OFFICIAL NOTICE OF DECISION

CITY OF ALBUQUERQUE
PLANNING DEPARTMENT
DEVELOPMENT REVIEW BOARD

9. Project # 1002531

SURVEYS SOUTHWEST LTD agent(s) for WAYNE A. MCFADDEN request(s) the above action(s) for all or a portion of Lot(s) 33 & 34, ALVARADO GARDENS, (to be known as **CIELO SU TIERRA SUBDIVISION**) zoned RA-2 residential and agricultural zone, located on GRANDE BLVD NW, between WILMA RD NW and VILLA DORO WAY NW containing approximately 3 acre(s). [REF: 03DRB-00604 SK, ZA-97-249] (G-13)

1" = 40'
 PROJECT NO. 0306RS07
 DRAWN BY: RS
 ZONE ATLAS: G-13-Z
 McFADDEN.CR5

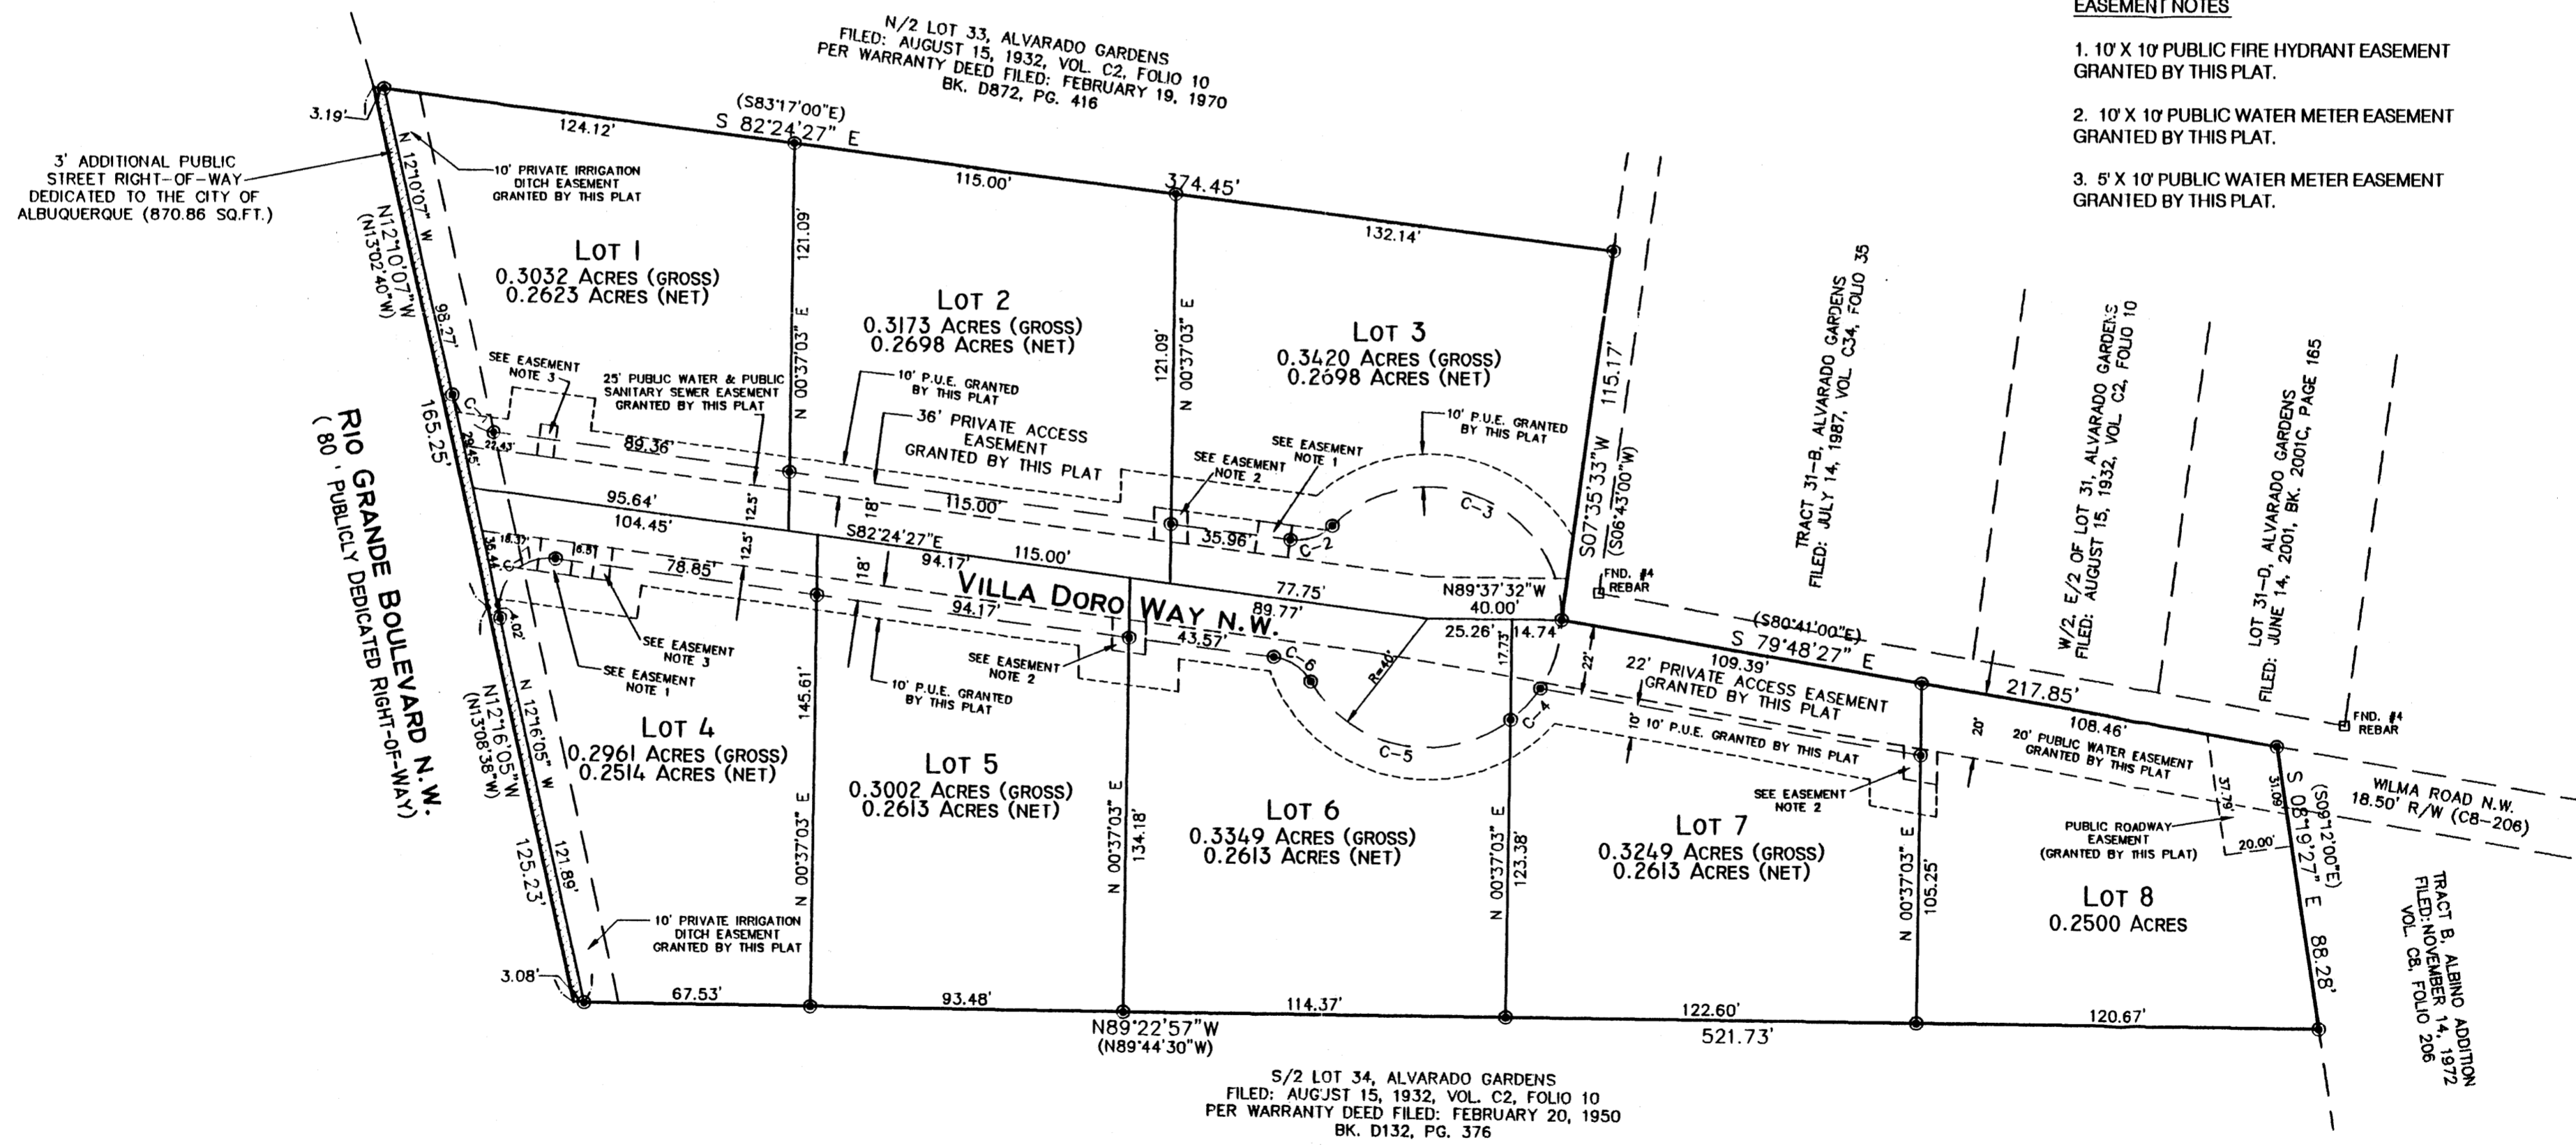
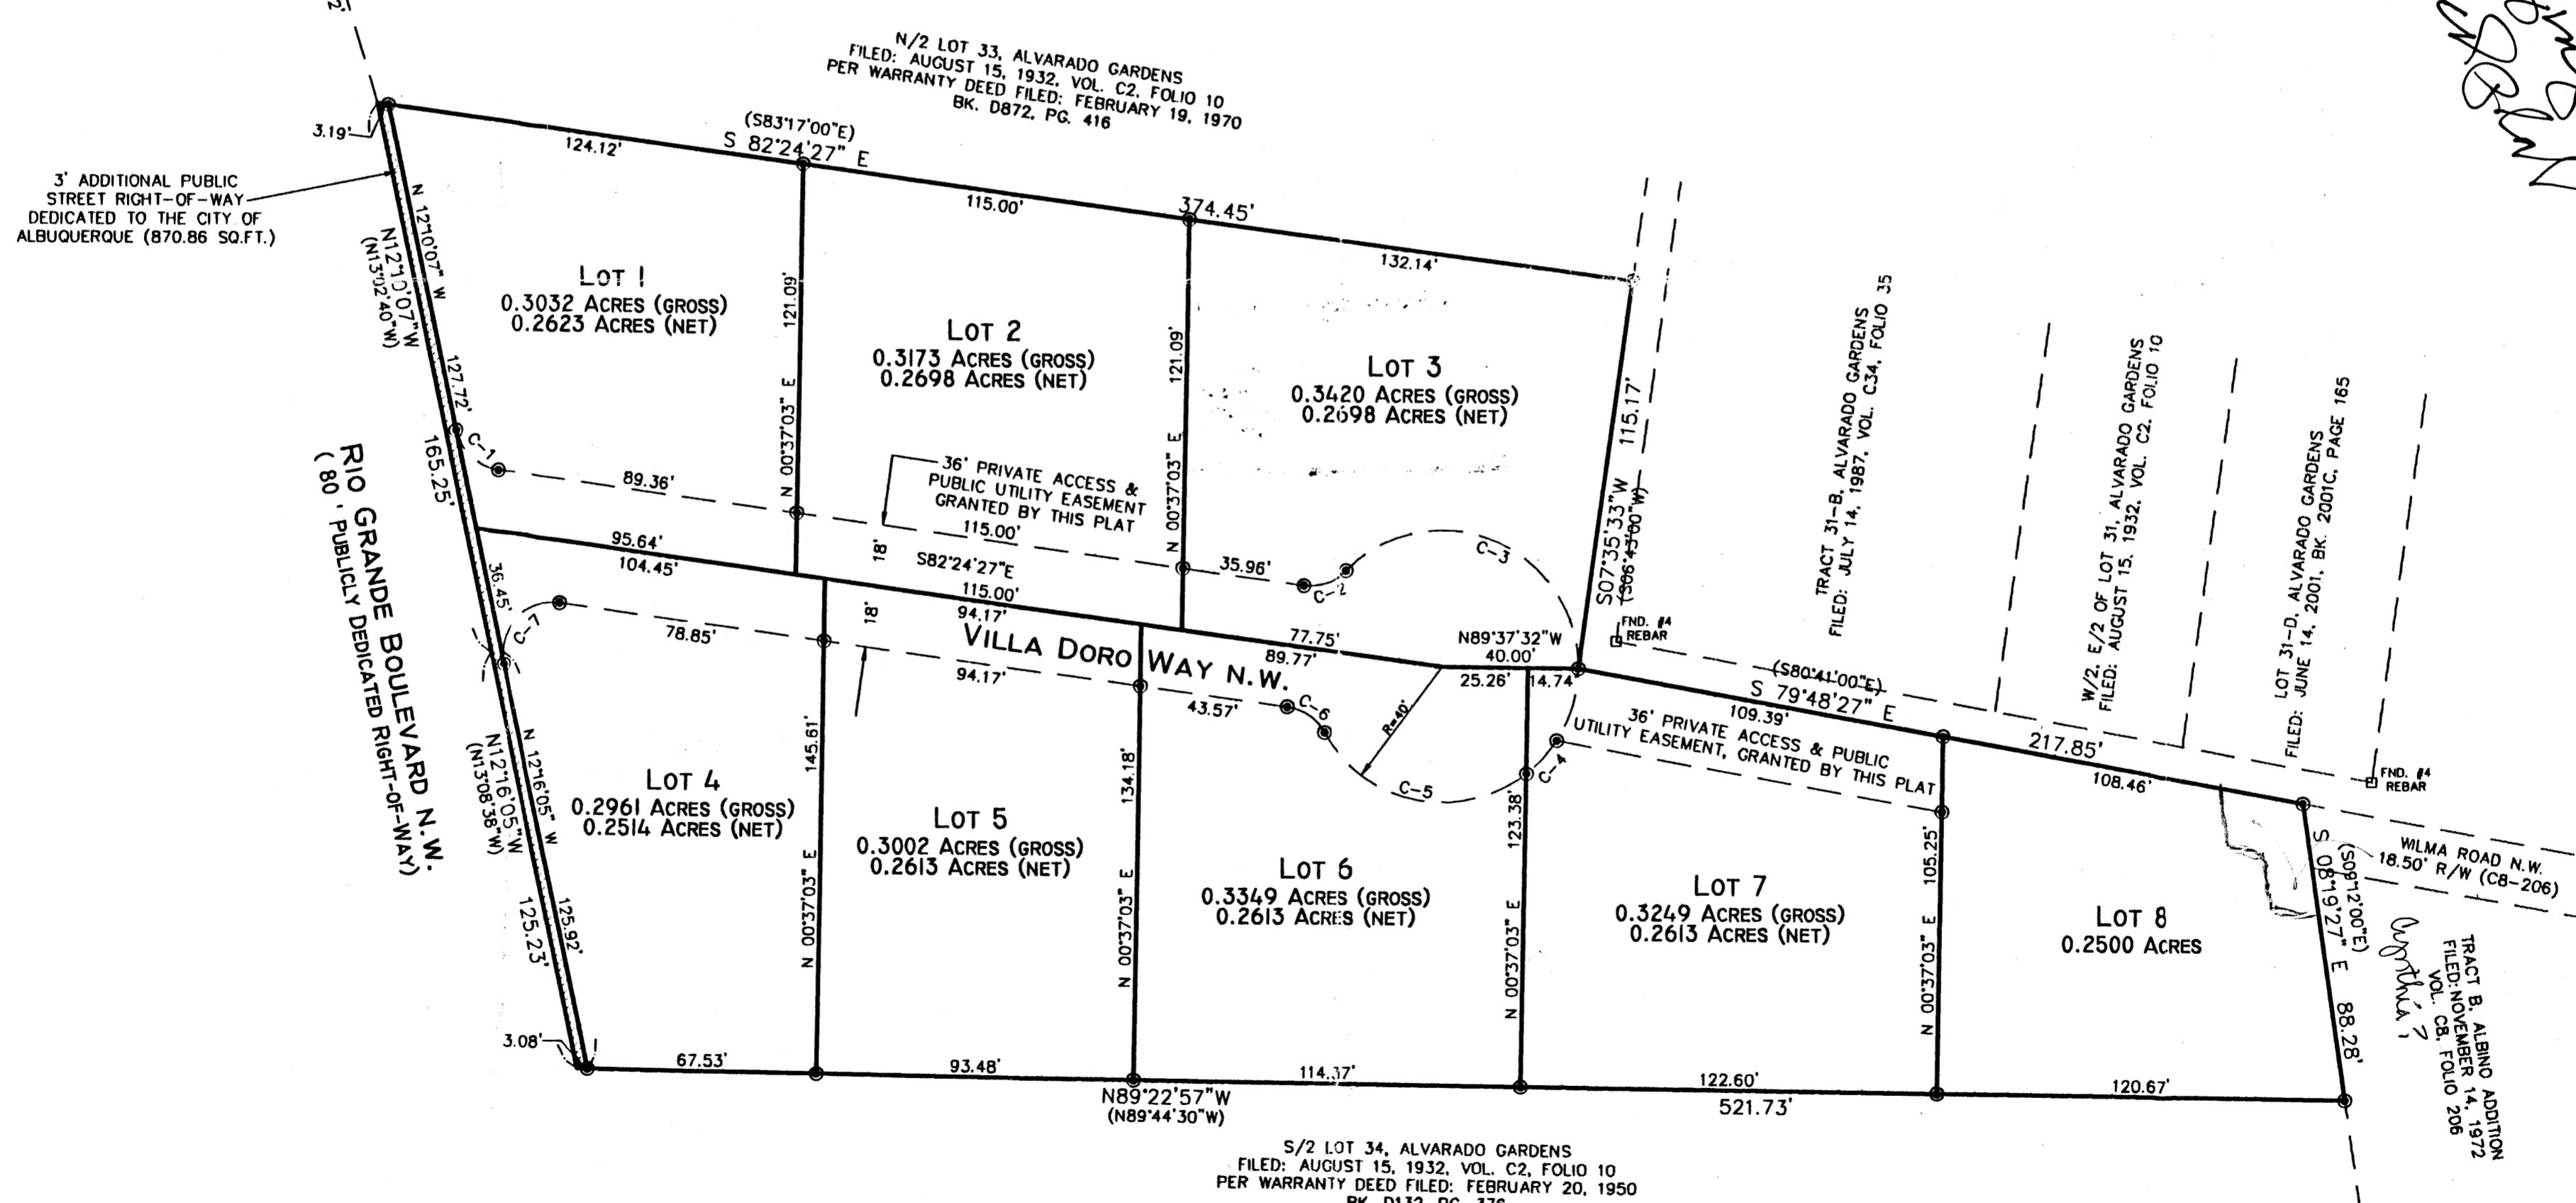
1. Wilma Street will need to meet the satisfaction of the Traffic Engineer on the final plat.
2. A turnaround or other appropriate dedication may be required.
